2021/0386

Detached dwelling including re-positioning of detached garage and formation of gabion retaining wall (part retrospective)

Thurlea, Old Mill Lane, Thurgoland, Sheffield, S35 7EG

PROPOSED LANDSCAPING (ADJ. RIVER DON) TO THE REAR OF "THURLEA" OLD MILL LANE THORSGOULD

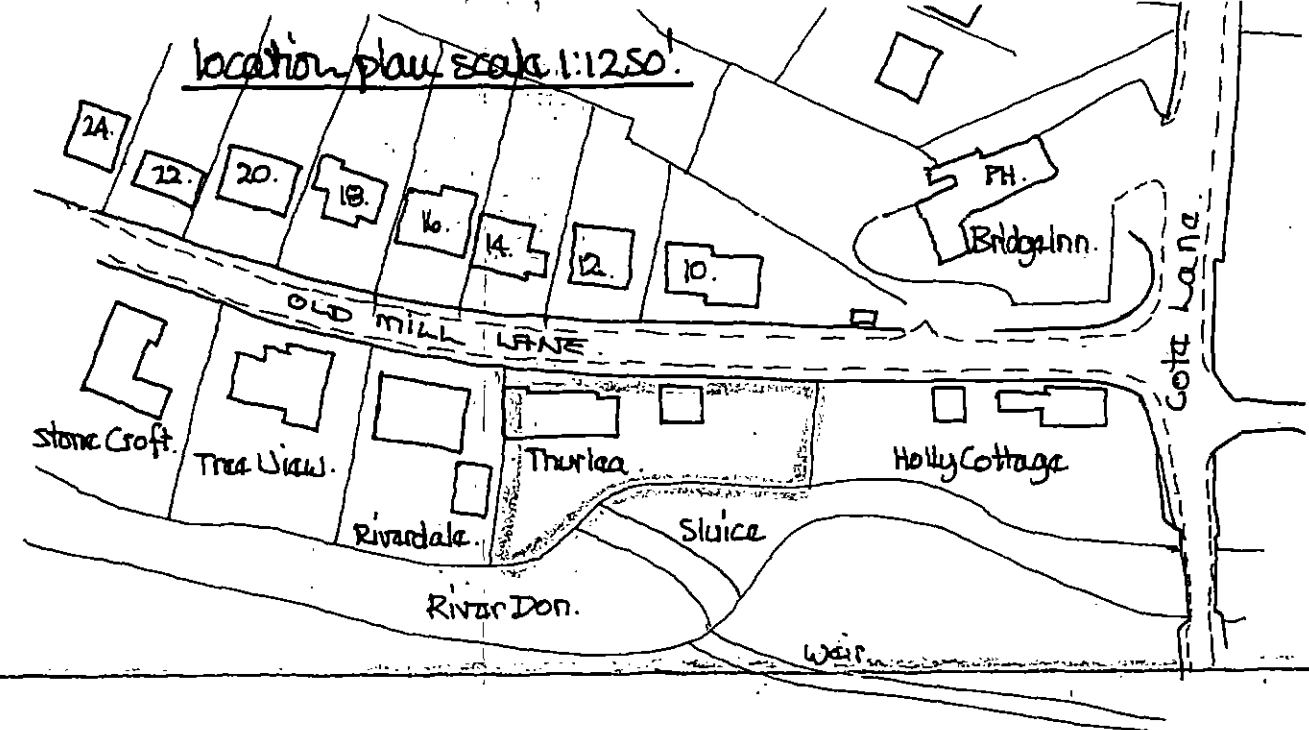
Gabion baskets - Thank you for the submitted information regarding the Gabion Baskets and copy of the consent for as granted in July 2013 for the works. However any consent granted at the time would have been for a maximum of 3 years only. This all changed after April 2016 with the introduction of Environmental Permitting Regulations (EPR) for Flood Risk Activities (replaces FD Consenting under WRA): so that any development within 8 metres of a watercourse would require a permit to carry out works.

The Environment Agency have not objected to the existing and proposed gabion baskets and wall built to the boundary with the River Don. The applicant had applied for a permit to the Environment Agency in July 2013 for the proposed wall to the rear of Thurlea, however it was only granted for a maximum of 3 years only. The regulations changed after April 2016 with the introduction of Environmental Permitting Regulations (EPR) for Flood Risk Activities, therefore any development within 8 metres of a watercourse would require a new permit to carry out works. The applicant has been made aware of the requirement for a permit for the works but this would be separate to the planning process.

Concerns have been raised with regard to the stability and safety of the proposed and existing gabion wall. The applicant has been made aware of the requirement for an Environment Agency permit for the works which is separate to any planning permission. The Council's Building Regulations have also confirmed that Building Regulation applications would be required for the proposed dwelling and existing/proposed gabion wall. The applicant has been informed of this matter and the agent has confirmed that applications to the relevant bodies will be prepared and submitted, should planning permission be granted for this development.

PROPOSED REBUILDING OF DETACHED DOUBLE GARAGE @ THURLEA OLD MILL LANE THURGOLAND.

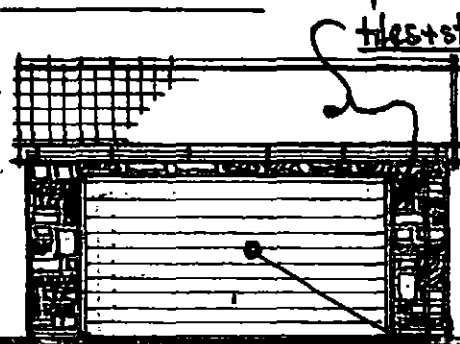
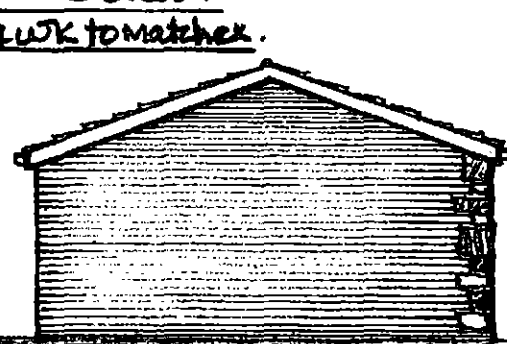
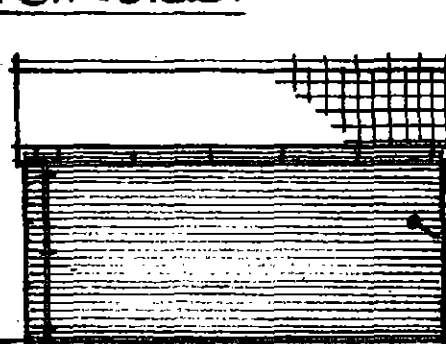
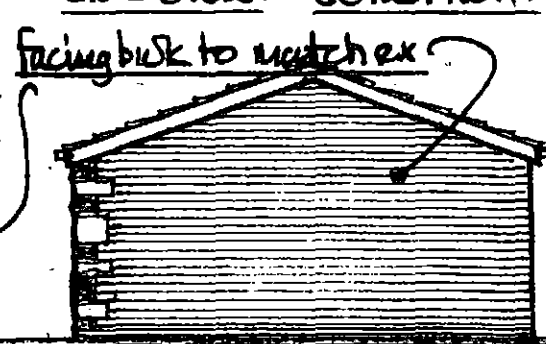
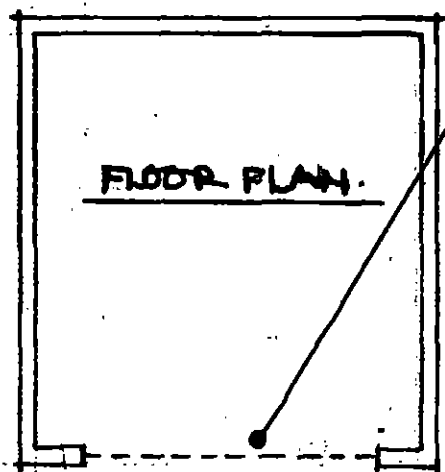
The only issue that needs to be addressed from a highways point of view is the length of the amended parking area for 'Thurlea'. The submitted plans appear to indicate that the replacement garage is to have an 'up and over' type door and as such the length of the parking area between the garage door and the site boundary needs to be a minimum of 6m in length rather than the 5.6m currently proposed. A length of 5.5m is acceptable if the garage is to have a roller shutter type door. The applicant has agreed to a roller shutter door to the garage and this can be secured by condition.

PROPOSED ELEVATIONS FROM RIVER.

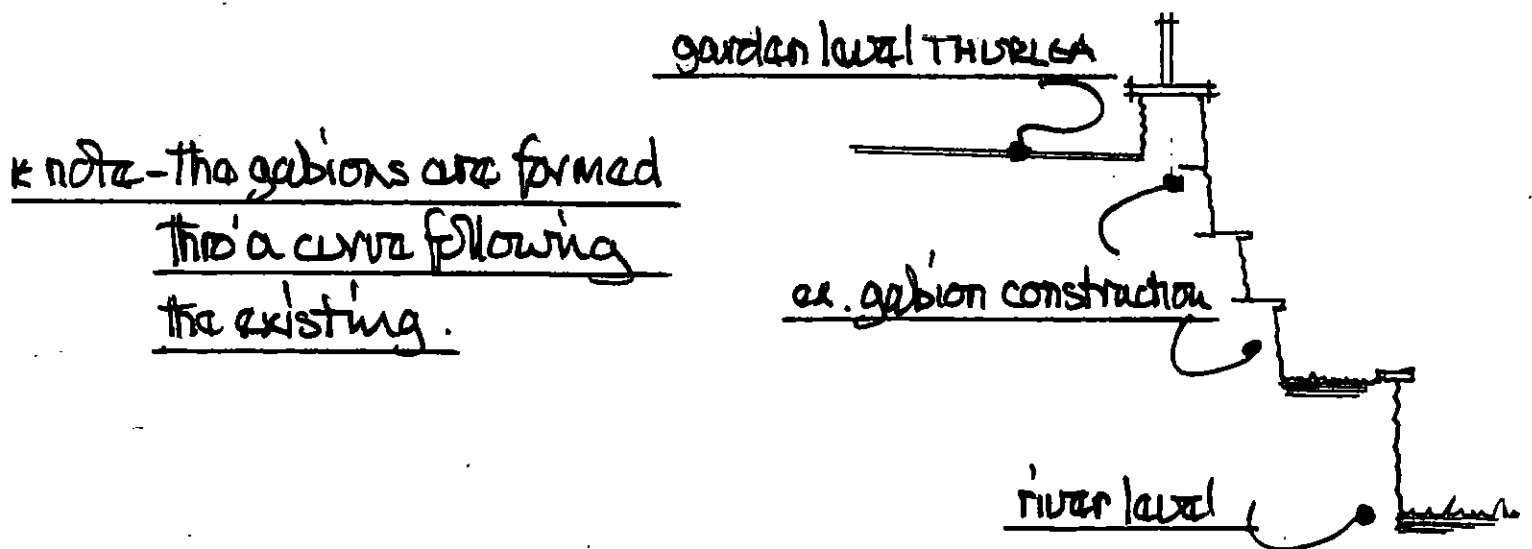
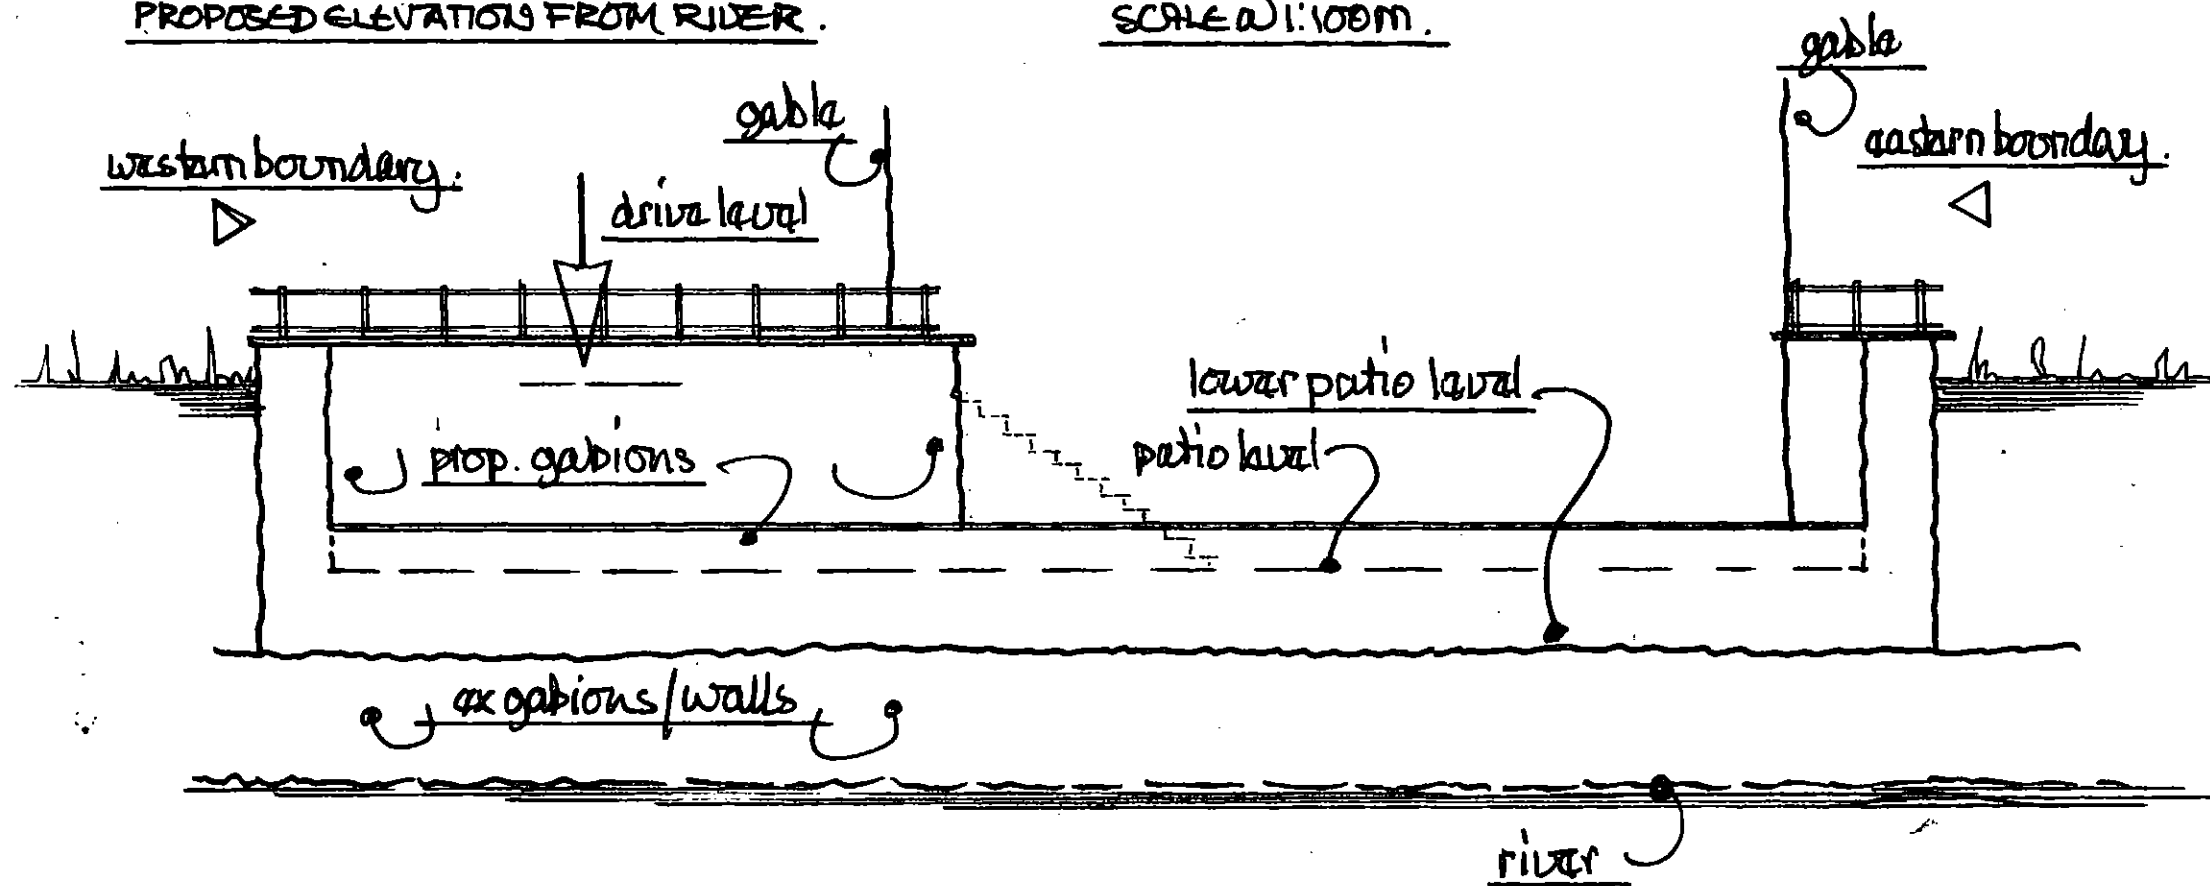
In terms of the proposed and existing gabion walls, these provide a visually acceptable solution to stabilise and provide a safe level garden/terrace area to Thurlea and the proposed dwelling. As can be seen from the existing wall built on site, the wall has been constructed with high quality materials and once the stone has weathered and the proposed landscaping is in place, the wall will blend into its surroundings and there would be a limited impact upon visual amenity and the Scheduled Ancient Monument.

The Conservation Officer has no objection to the proposal. Historic England provided further advice during the processing of the application, confirming that on the basis of the proposed planting to allow the gabion wall blend into the landscape and further information on the reasons for this bank protection, Historic England did not object to this application. The agent has now submitted a revised heritage statement outlined above which includes justification and plans to plant the existing and proposed gabion wall to allow it to blend into the landscape. This overall harm caused by the gabions will be mitigated with planting/greening/ageing of the gabion structures to soften the setting and the proposal. The proposal is therefore considered acceptable in terms of the overall impact upon the Scheduled Ancient Monument and therefore complies with paragraph 194 and 195 of the National Planning Framework Policy (NPPF) and policies HE1, HE2 and HE3 of the Local Plan.
